Comment Log for Rolling Meadows Channel & Floodplain Modification - 60% Design Plans

REVIEWERS			MATRIX RESPONSE			REVIEWERS' RESPONSE		
Reviewers: El Paso County Engineering & El Paso County Stormwater			3/1/2023		Disposition Key: A = Will Incorporate, B = Will Evaluate, C = Will Incorporate in Later Submittal, D = Other		Date: 3/06/2023

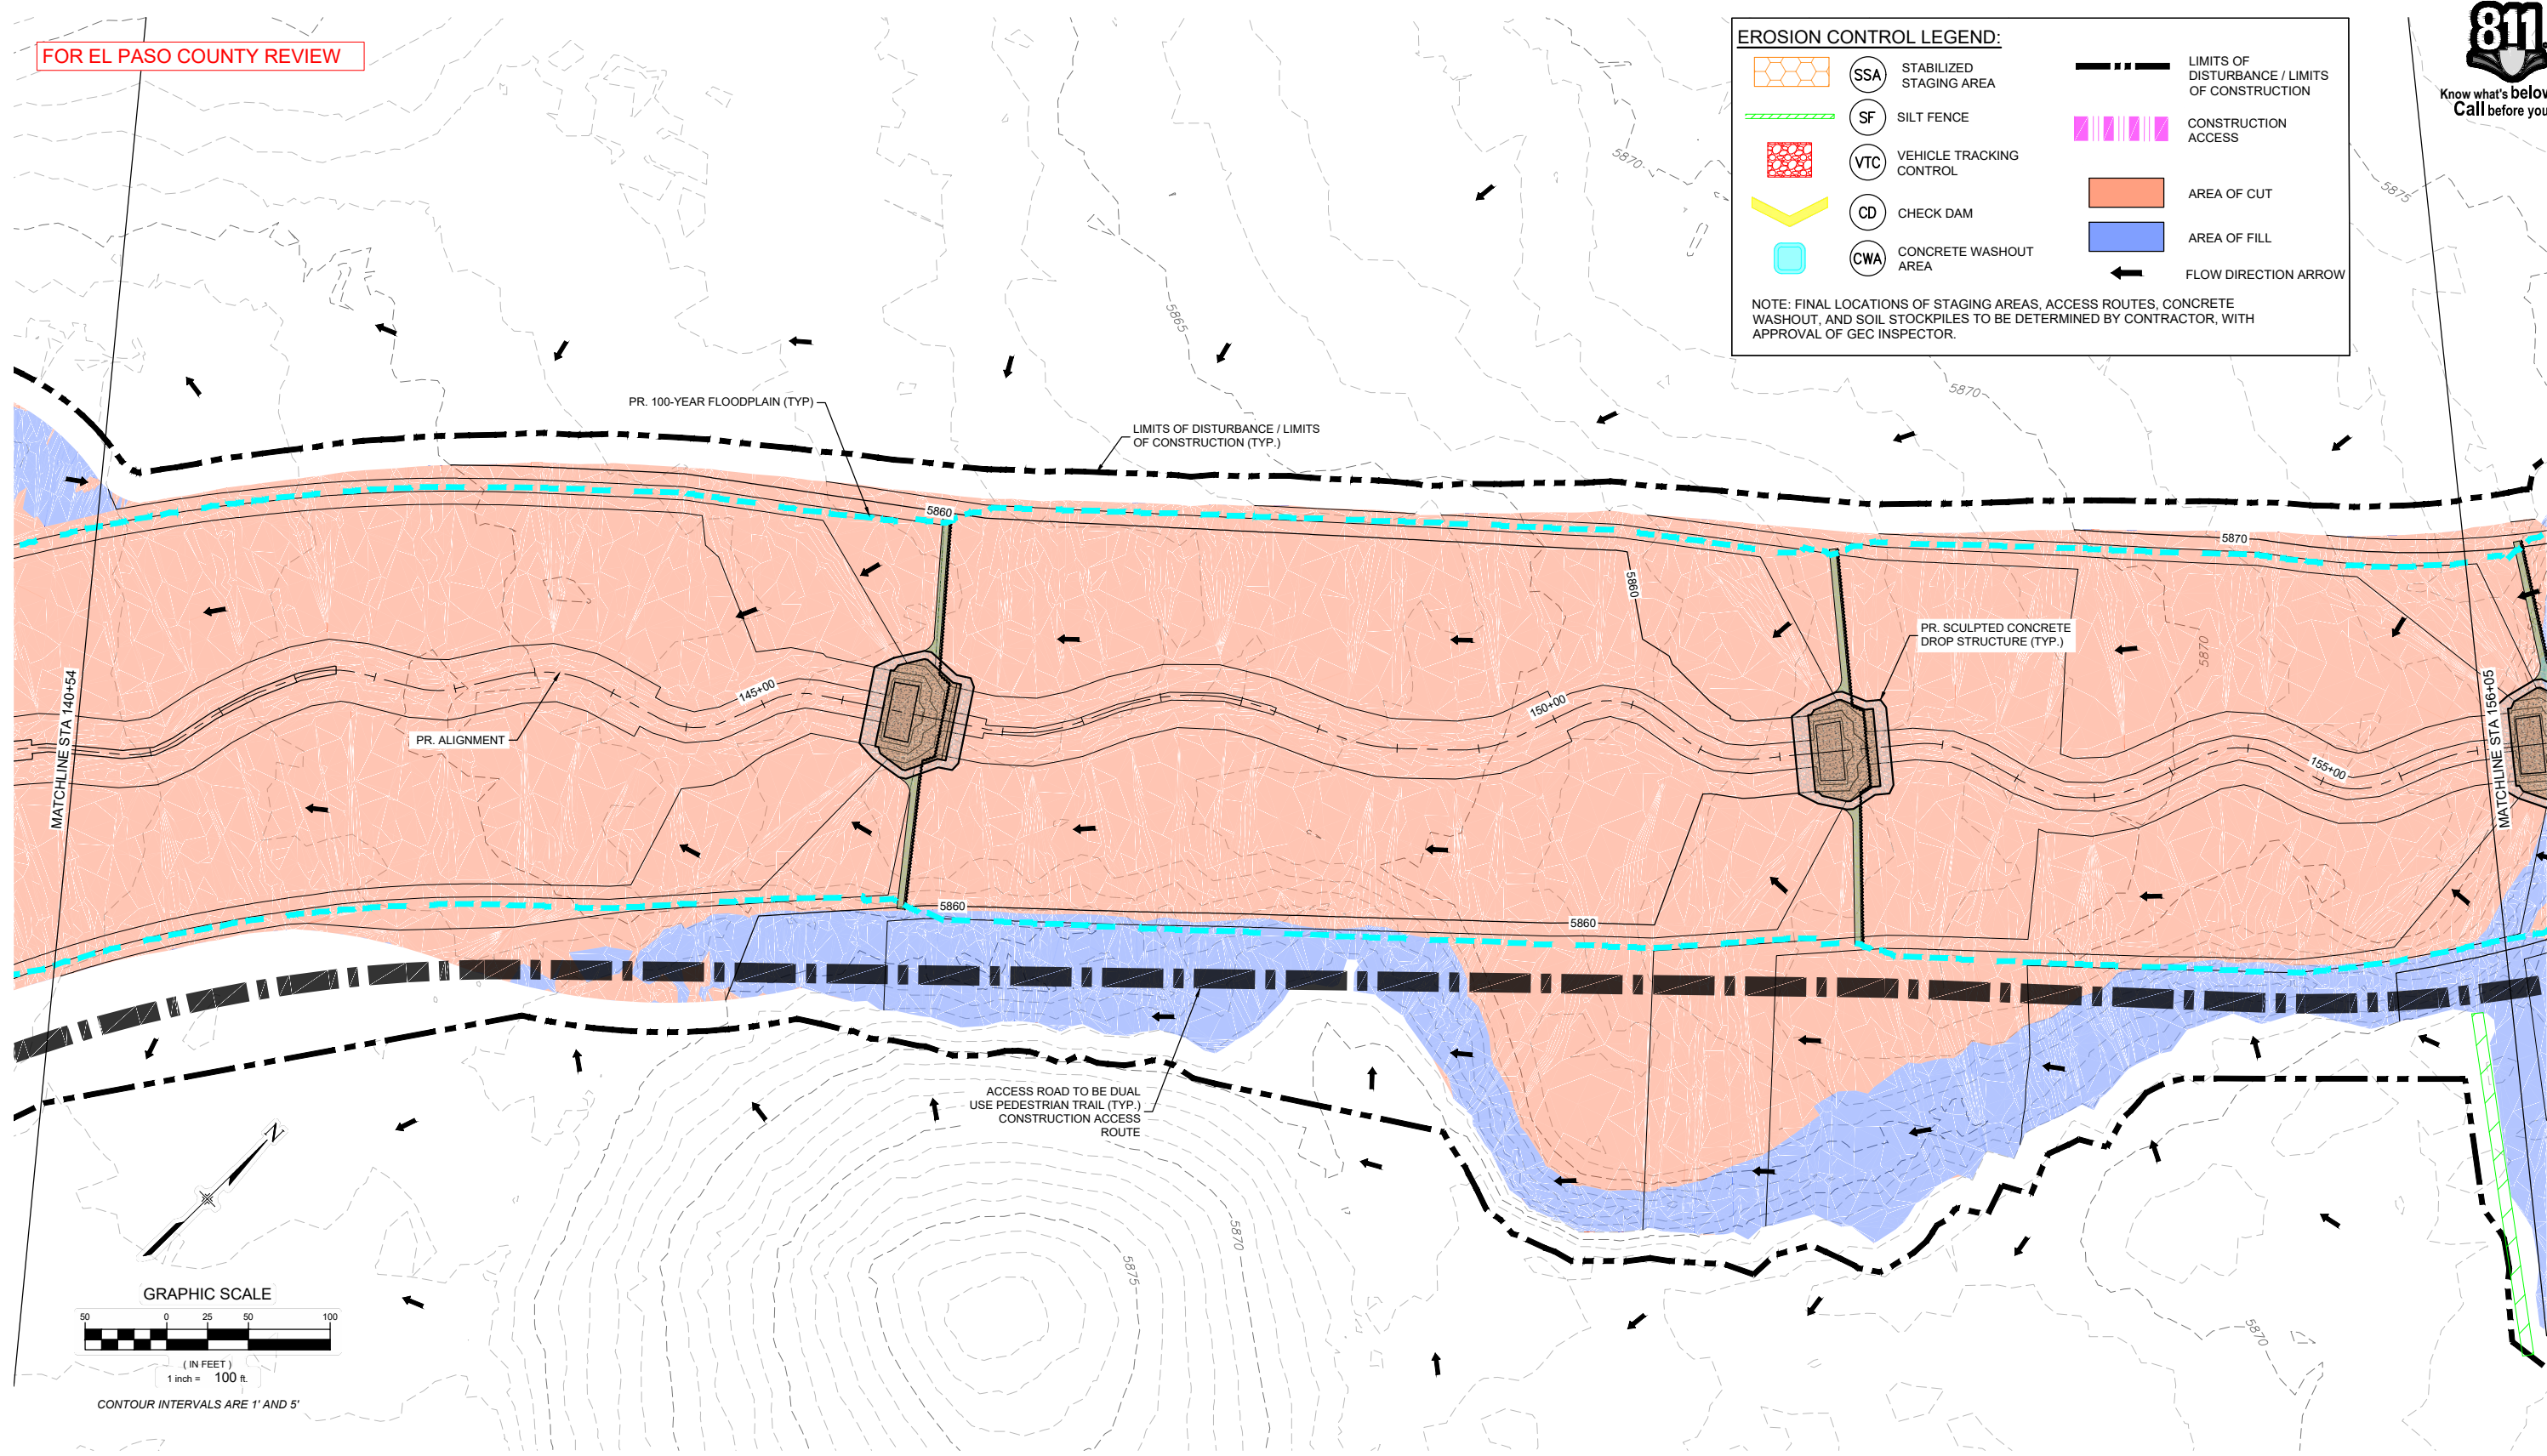
44	EC09	label street	EPC Stormwater	A	Labeled	EAL	✓	CP
45	EC11	show stormwater flow direction and add BMPs if flowing offsite to the south	EPC Stormwater	A	Additional labels added near road embankment.	EAL	✓	CP
46	EC12	straw wattles or silt fence	EPC Stormwater	A	Silt fence added to areas shown on EC12 & EC15	EAL	✓	CP
47	EC15	label roadway	EPC Stormwater	A	Labeled	EAL	✓	CP
48	EC17	Provide a copy of County VTC detail as it is different than City's.	EPC Engineering	A	EPC VTC detail added.	EAL	✓	CD

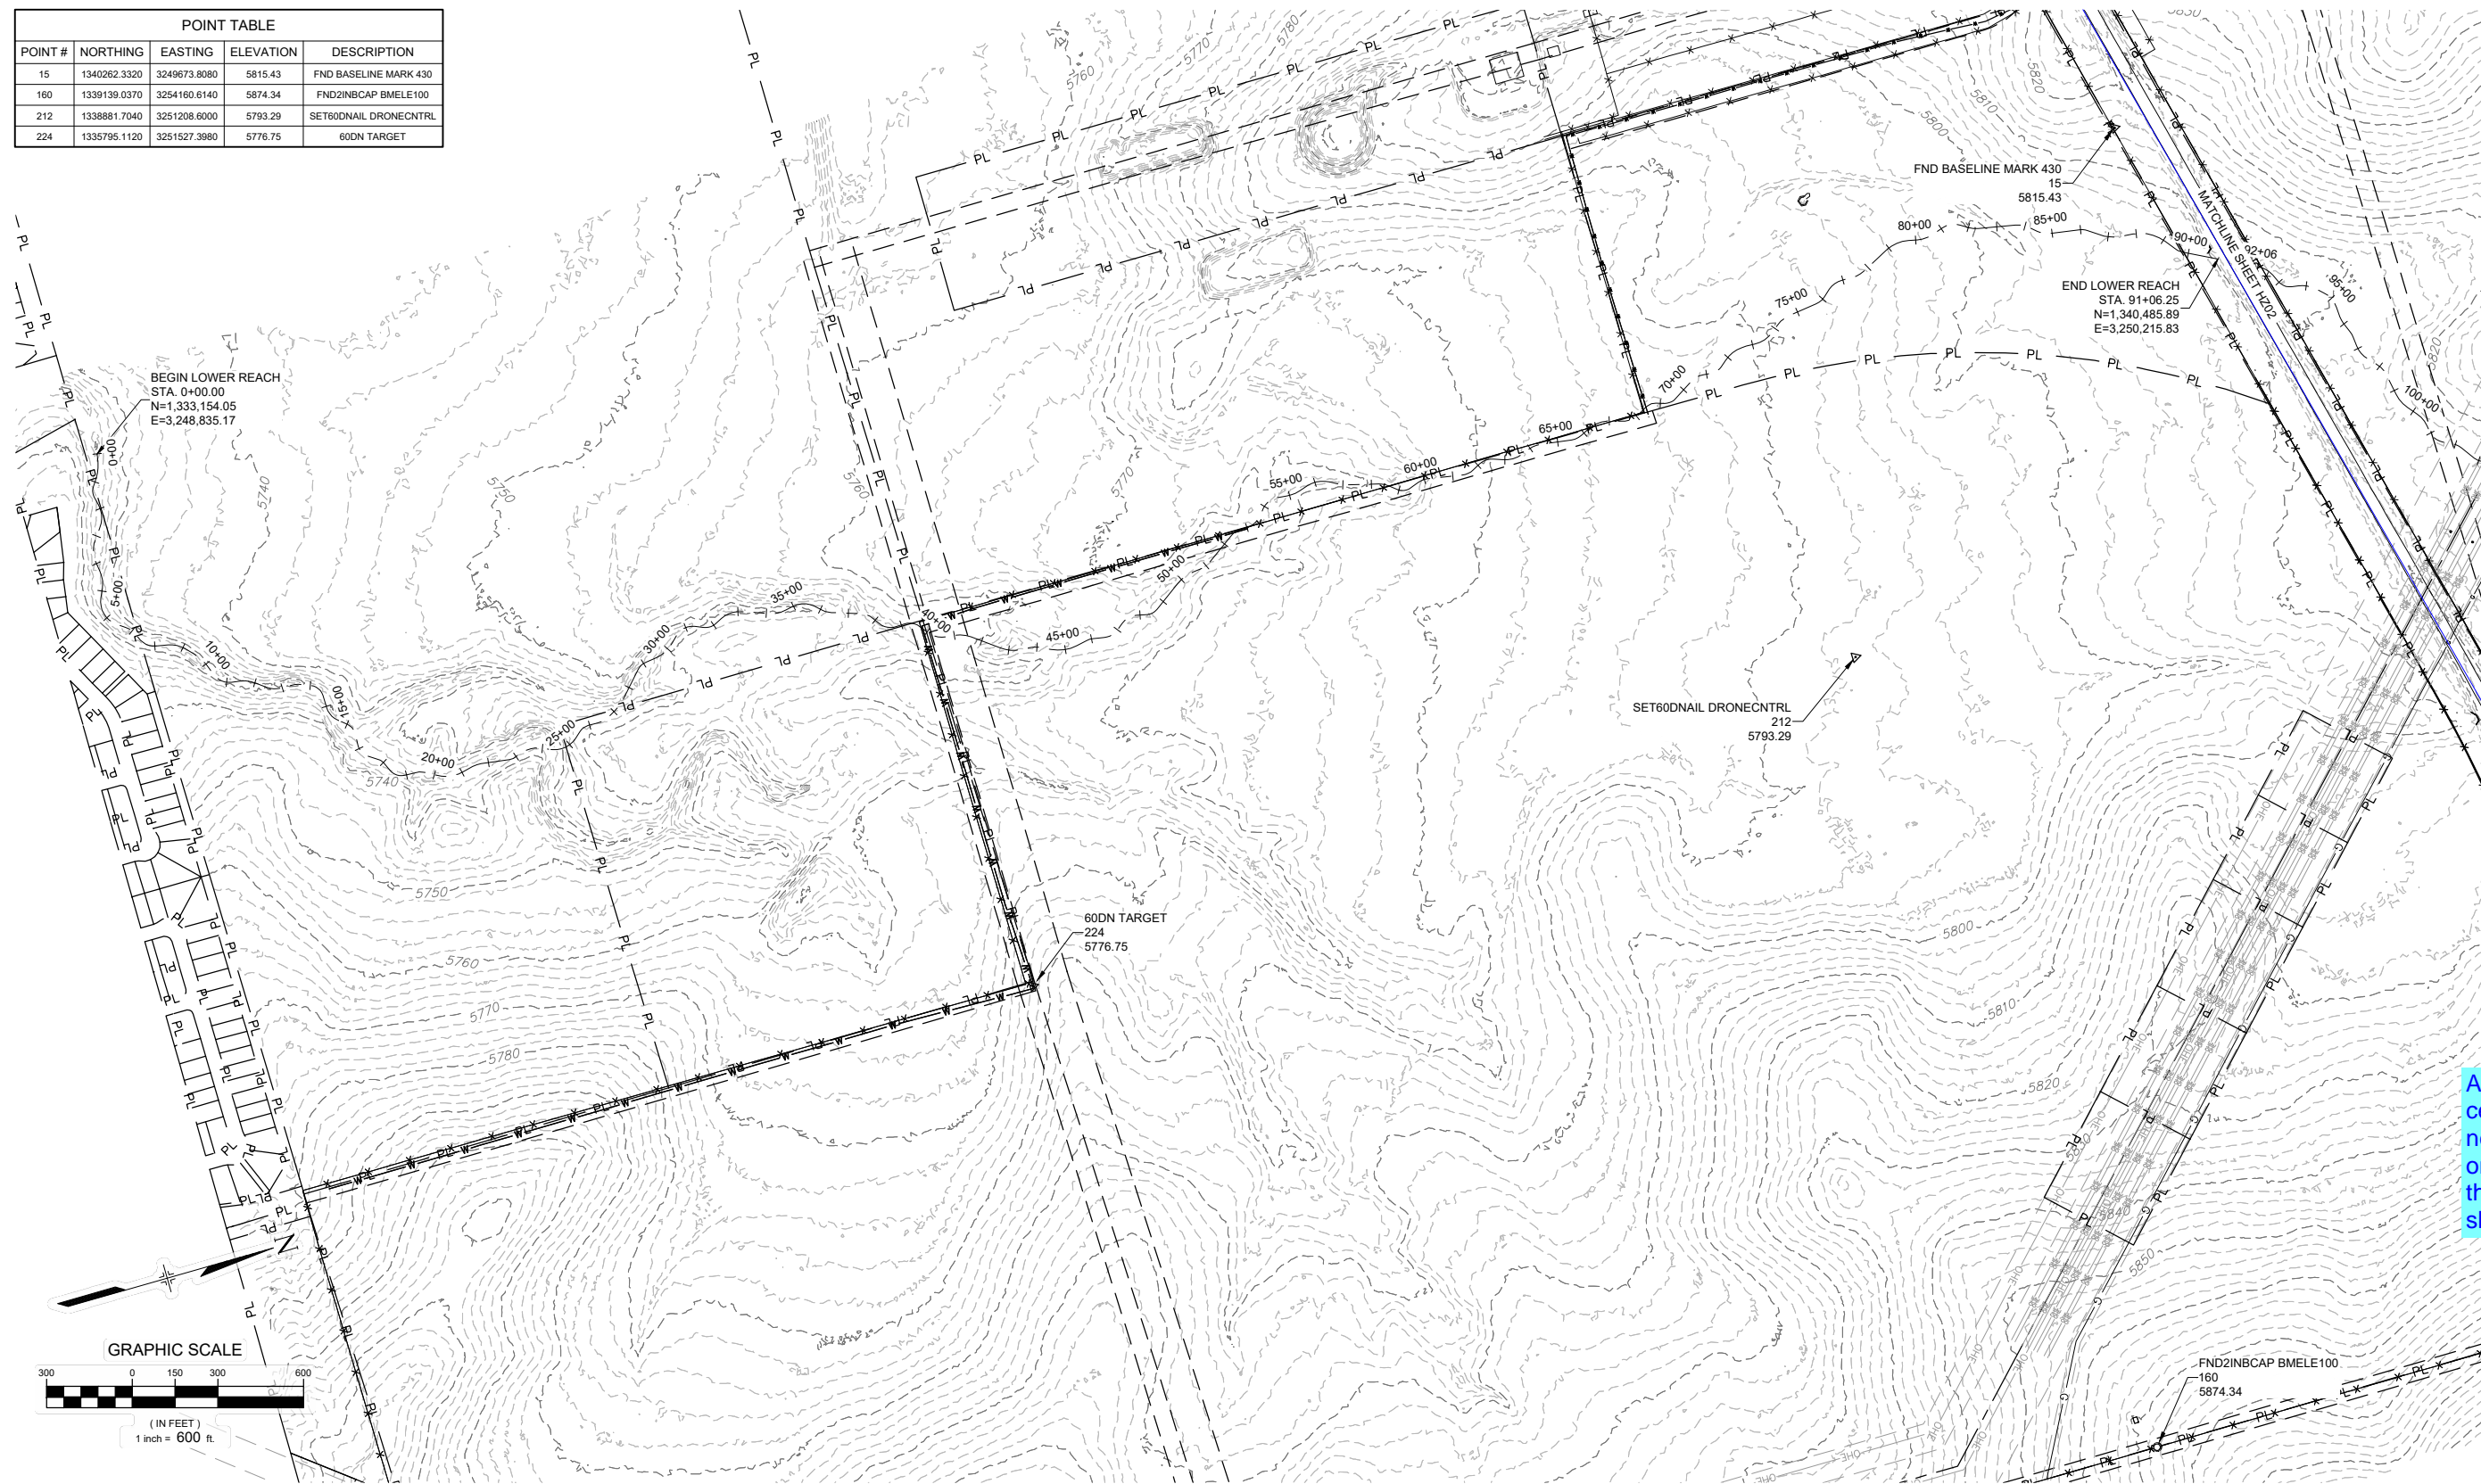
7	HZ01/02	Alignment table or centerline labels will need to be added on this sheet or on the plan & profile sheets	EPC Engineering	A	Line & curve tables added on HZ03	EAL	Add line and curve labels to HZ01 and HZ02	CD/JR
8	EC01	These sheets should be included in the GEC Plan or all GEC Plan Sheets should be added to the Design Plan	EPC Stormwater	A	Removed	EAL	Add these sheets to GEC Plan?	CP
9	PP03	Move scale off of text	EPC Engineering	A	Label moved	EAL	✓	JR
10	PP03	Show existing maint. trail	EPC Engineering	A	Ex. Maintenance trail showing	EAL	✓	JR
11	PP03	Label beginning of construction	EPC Engineering	A	Label added to Plan and Profile view	EAL	See comment about transition/tie-ins	JR
12	PP03	Per ECM Section 3.3.3.K.1 for channels longer than 1000 ft, ramps need to be provided to bottom of channel every 500 ft	EPC Engineering	C	Can you clarify? The standard reads that this is for channels greater than 10 ft deep AND 1,000 ft in length. Per DT01, our max depth is less than 10 ft. so does this apply? If required, we can incorporate this at 90%.	TKM	If access is provided to each drop structure that will be fine.	JR
